Our Reference: SYD16/00526/02
Department Ref: SSD 7603

DOOLEYS CATHOLIC CLUB LIDCOMBE – CONCEPT PROPOSAL FOR TOURIST RELATED PURPOSES AND DETAILED PROPOSAL FOR EARLY WORKS – NOTICE OF EXHIBITION

Aleks Tancevski
Senior Land Use Planner
Network Sydney South Precinct

2 SITE ACCESS
1 : 1500

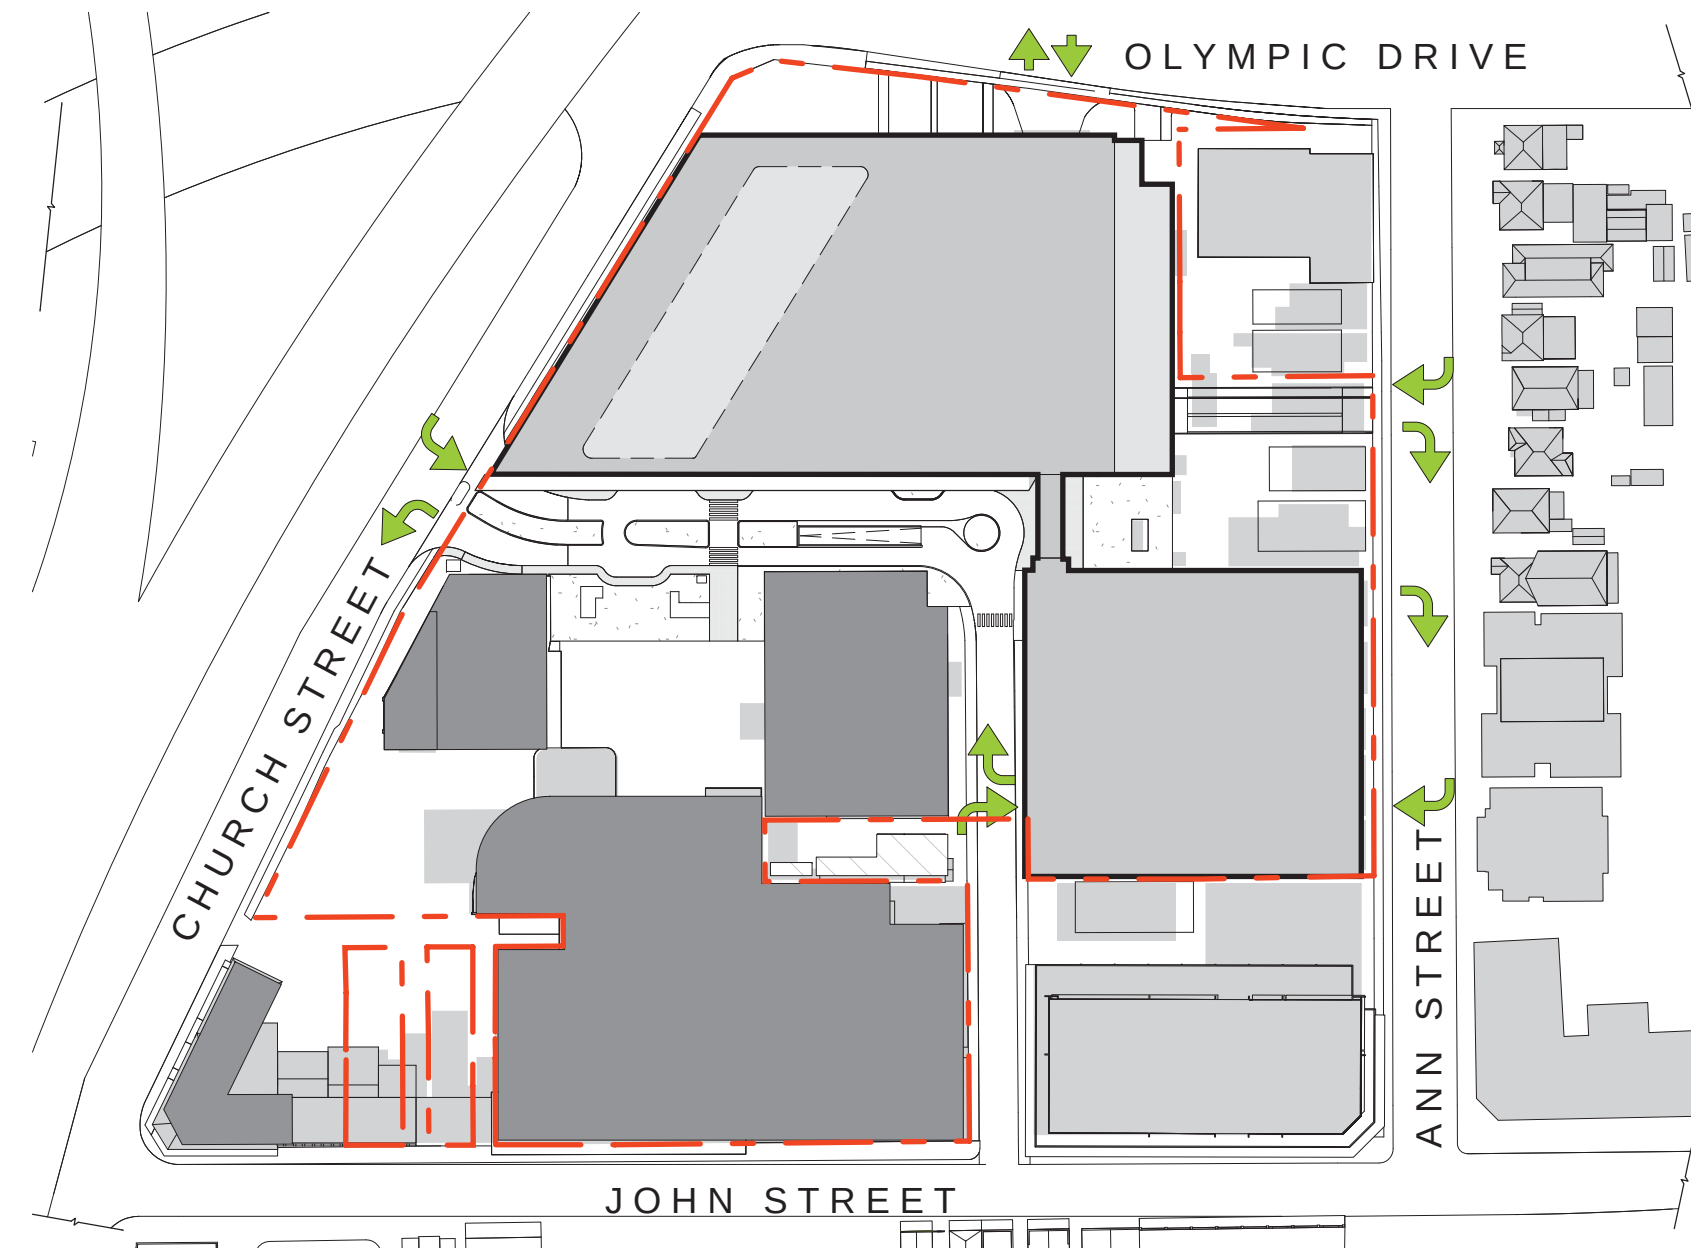
- Opening of Ann Street to Olympic Drive
- Opening of Board Street to Olympic Drive
- Opening of Olympic Drive to truck only movements into the development

The Traffic Impact Assessment (TIA) details the above 'in-principal' agreements relating to the above proposals for additional access onto Olympic Drive. The relevant documents were prepared in December 2015. The effective management of the State road network is a critical issue. A current Premier's priority is that 90% of peak travel on key road routes is on time.

The proponent should seek an updated view from Roads and Maritime, endorsed by the Roads and Maritime Principal Network Manager – South Precinct, on the proposals outlined in the Car Parking and Traffic Report to open Ann Street to Olympic Drive, to open Board Street to Olympic Drive and to allow truck only movements from Olympic Drive into the subject development.
